# **A46 Newark Bypass**

**Scheme Number: TR010065**

## **Statement of Common Ground with Think Again A46 Winthorpe Action Group**

**Statement Of Common Ground with  
Think Again A46 Winthorpe Action Group - TA**

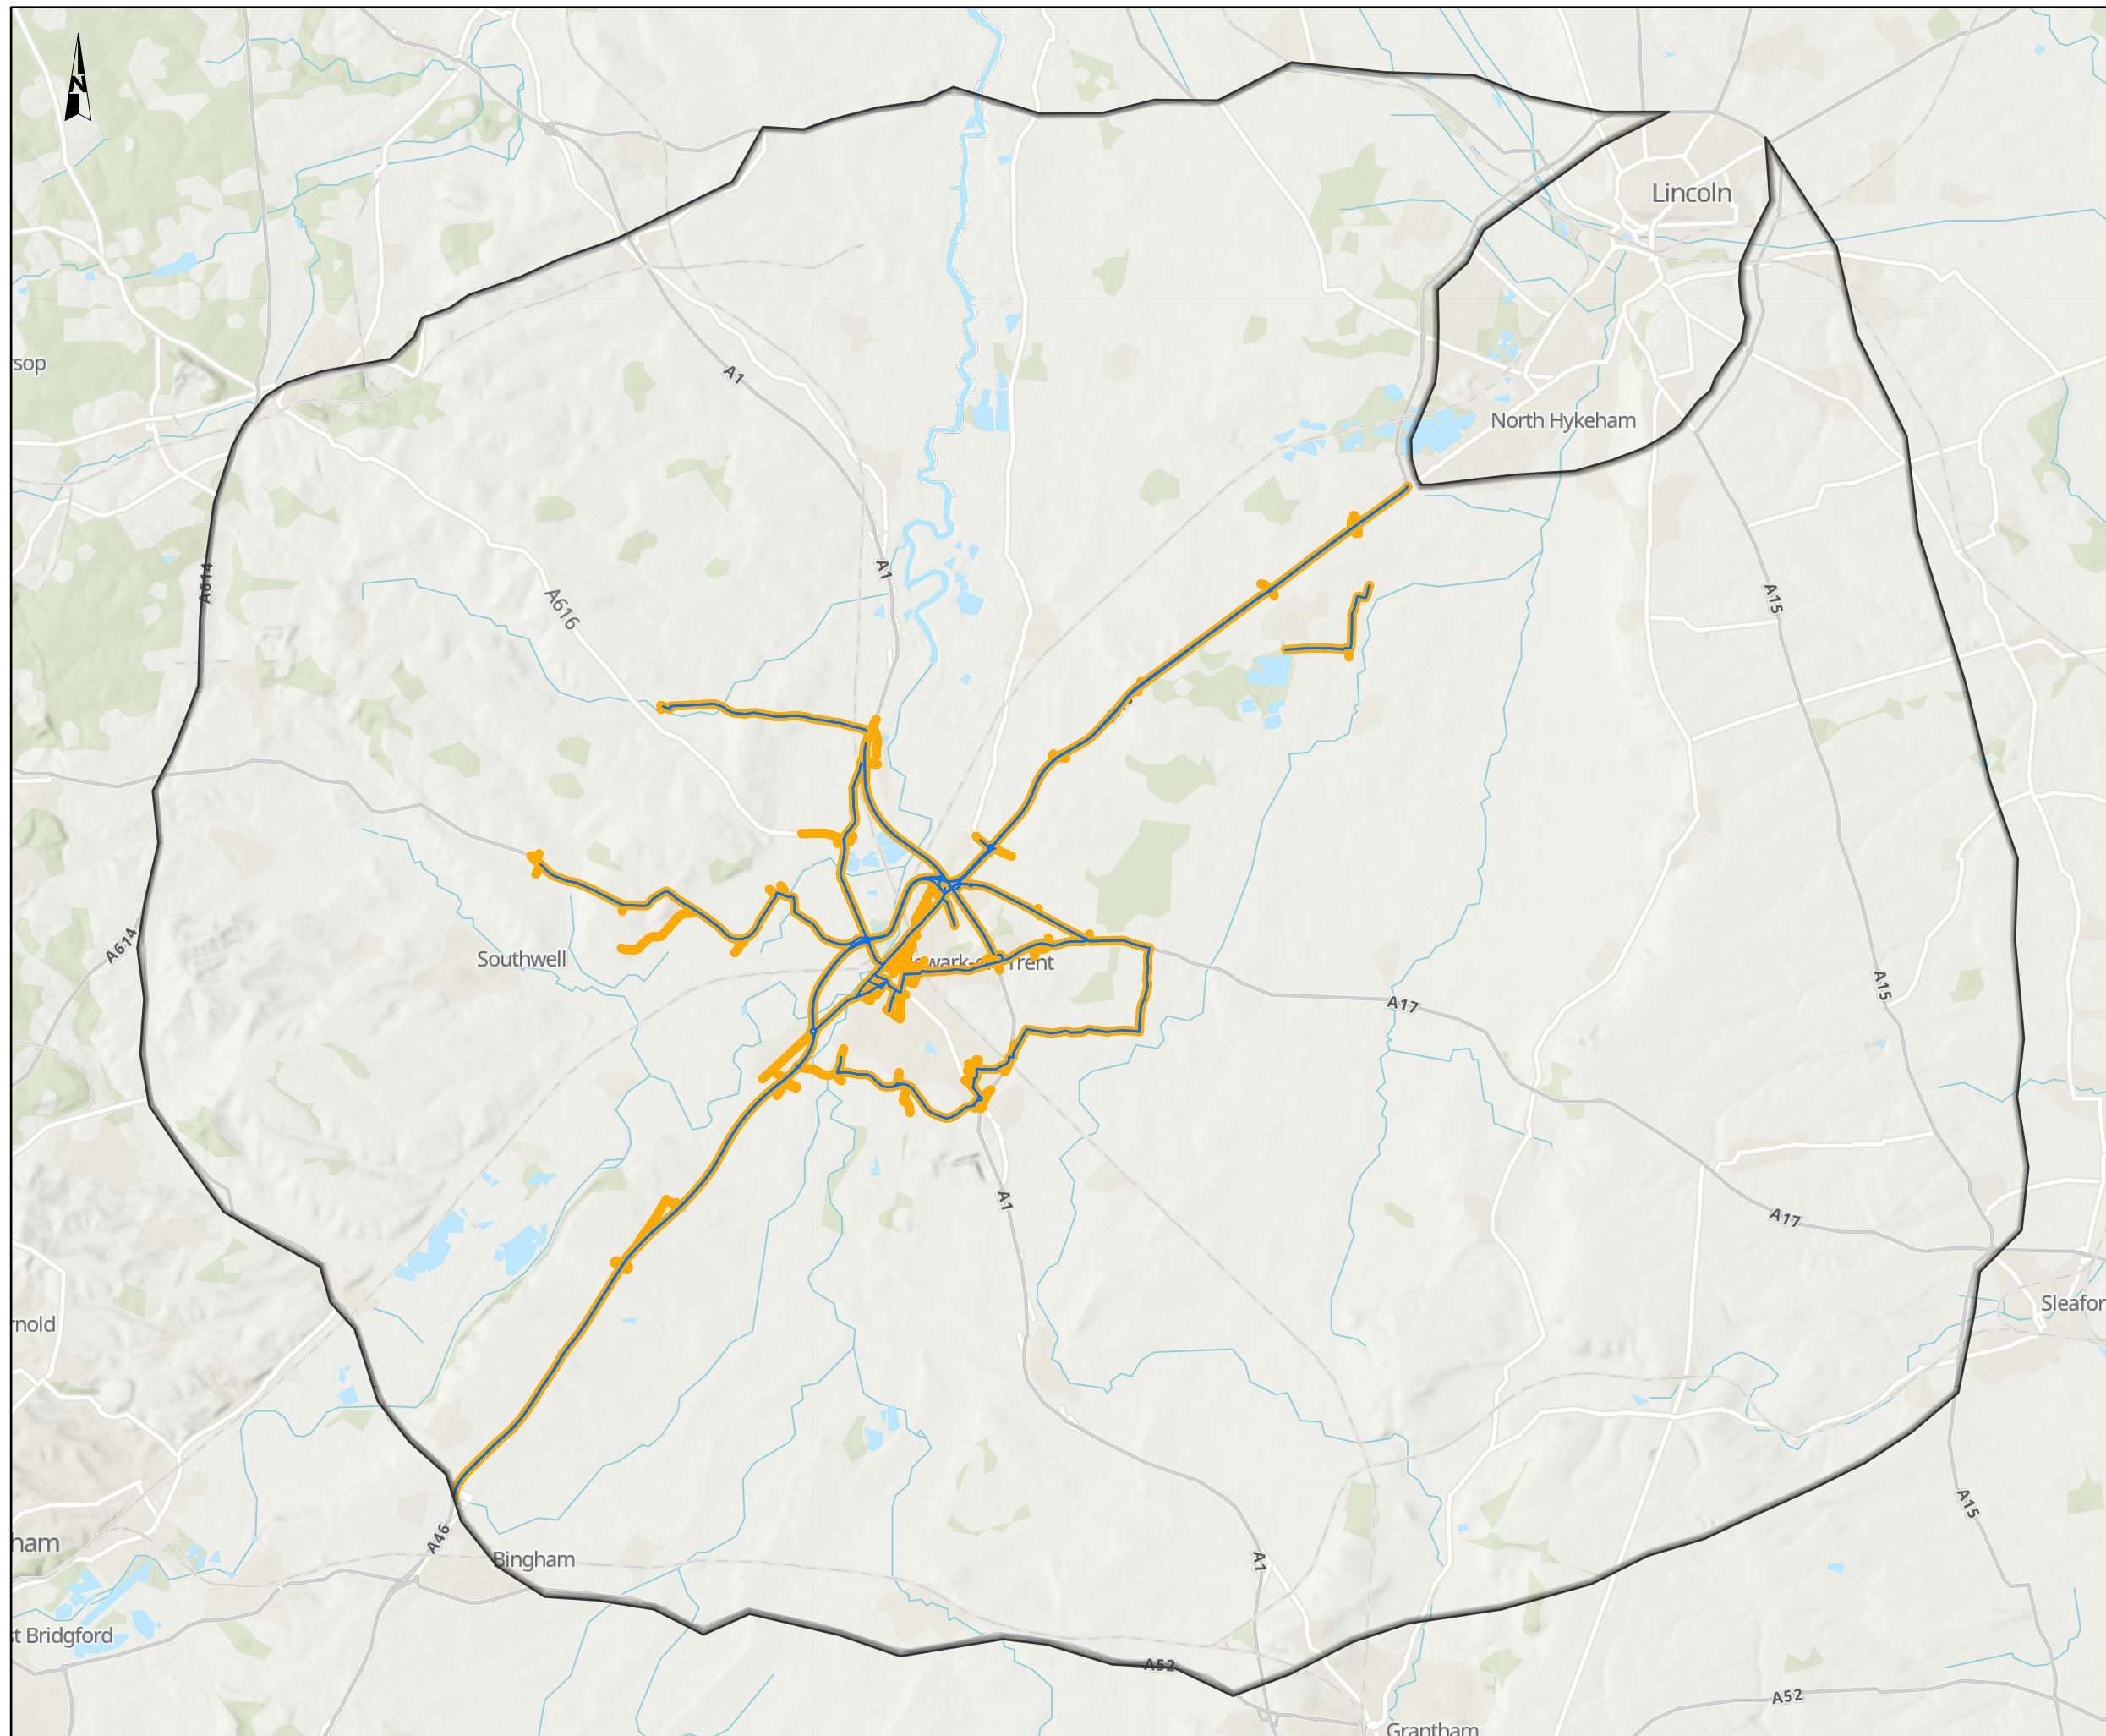
17.	Air Quality	Chapter 5 Air Quality of the Environmental Statement [AS-021] Figure 5.4 Air Quality Affected Road Network of the Environmental Statement Figures [AS-031] Design Manual for Roads and Bridges LA 105 – Air Quality LA 105 – Air Quality	What measures will be put in place to minimise the spread of pollution from road traffic to adjacent properties, some already noted as amongst the 12 most impacted receptors in the analysis area, together with pedestrian routes adjacent to the road	The assessment presented in Chapter 5 Air Quality of the Environmental Statement [AS-021] assesses the impacts of the Scheme on air quality.  Dispersion modelling was undertaken as part of the air quality assessment using ADMS-Roads, which is a PC-based model of dispersion in the atmosphere of pollutants released from road traffic sources. The dispersion modelling accounts for all roads within the study area that meet the criteria for assessment. Dispersion modelling to determine the air quality effects includes all roads within 200m of 'affected' roads where they add to total pollution concentrations. Roads modelled within the air quality assessment are presented in Figure 5.4 Air Quality Affected Road Network of the Environmental Statement Figures [AS-031].  Human health receptors have been chosen at sensitive locations within 200m of the air quality affected road network and include residential properties, schools and hospitals (where present), in line with the Design Manual for Roads and Bridges LA 105 – Air Quality. The air quality objectives are not typically assessed at footpath locations as the short-term (1-hour) air quality objectives are unlikely to be exceeded and members of the public are not reasonably expected to spend one hour or longer at any single location along a footpath.  Winthorpe village and Langford are located over 200m away from the affected road network and therefore have not been included in the assessment. However, human receptors along the A46 and A1 on the outskirts of Winthorpe, which are within 200m of the affected road network, have been included in the assessment. The predicted concentrations at these receptors,	Agreed	12/12/2024

Issue No.	Issue	Document Reference	Think Again Position	The Applicant's Position	Status	Date status confirmed
				<p>which are below the air quality objectives, are likely to have the highest pollutant concentrations or anticipated to experience highest level of change within the vicinity of Winthorpe village and Langford.</p> <p>During operation of the Scheme there are not predicted to be any exceedances of the NO<sub>2</sub> or particulate (PM<sub>10</sub> or PM<sub>2.5</sub>) air quality objectives (40ug/m<sup>3</sup> for NO<sub>2</sub> and PM<sub>10</sub>, and 20ug/m<sup>3</sup> for PM<sub>2.5</sub>) at any human health receptors within the study area. The maximum modelled concentration for NO<sub>2</sub> in the opening year of the Scheme is predicted to be 31.9ug/m<sup>3</sup>. The maximum modelled concentration for PM<sub>10</sub> in the base year of the Scheme is predicted to be 28.9ug/m<sup>3</sup>.</p> <p>Figure 5.5 Air Quality Summary of Traffic Data of the Environmental Statement Figures [AS-032] provides detail on why PM<sub>2.5</sub> has not been considered further within the operational phase of the local air quality assessment.</p> <p>In summary, the Design Manual for Roads and Bridges LA 105 – Air Quality states that there should be no need to model PM<sub>2.5</sub> as the UK currently meets its legal requirements for the achievement of the PM<sub>2.5</sub> air quality thresholds and modelling of particulates (PM<sub>10</sub>) can be used to demonstrate that the Scheme does not impact on the PM<sub>2.5</sub> air quality threshold. For this assessment, when the maximum modelled road contribution of PM<sub>10</sub> of 4.5 µg/m<sup>3</sup> from existing traffic in the base year at modelled receptors is combined with the maximum PM<sub>2.5</sub> background concentration of 9.7 µg/m<sup>3</sup> across the study area, the PM<sub>2.5</sub> threshold of 20 µg/m<sup>3</sup> is not exceeded.</p> <p>Considering PM<sub>2.5</sub> is also a constituent part of PM<sub>10</sub>, vehicles emission factors, and therefore the existing road contributions, for PM<sub>2.5</sub> would be even lower than those for PM<sub>10</sub>. Further to this, the greatest change in annual mean nitrogen dioxide (NO<sub>2</sub>) concentrations at modelled receptors in the opening year of the Scheme is predicted to be 3.9 µg/m<sup>3</sup> between the Do Something (with the Scheme) and Do Minimum (without the Scheme) scenarios. Changes in PM<sub>2.5</sub> would therefore be even lower in the opening year of the Scheme, as PM<sub>2.5</sub> is a constituent part of PM<sub>10</sub> and PM<sub>10</sub> emissions are an order of magnitude lower than nitrogen oxide (NO<sub>x</sub>) emissions which are primarily made up of nitric oxide (NO) and NO<sub>2</sub>. As well as this, PM<sub>2.5</sub> background concentrations are expected to continue falling in the future.</p> <p>Therefore, it can be concluded that the current and future PM<sub>2.5</sub> concentrations are lower than the current target value of 20 µg/m<sup>3</sup> and the Scheme will not impact on the PM<sub>2.5</sub> air quality threshold at any of the human health receptors considered and no further assessment is required.</p> <p>Therefore, no significant air quality effects are anticipated as a result of the Scheme and no mitigation measures are proposed</p>
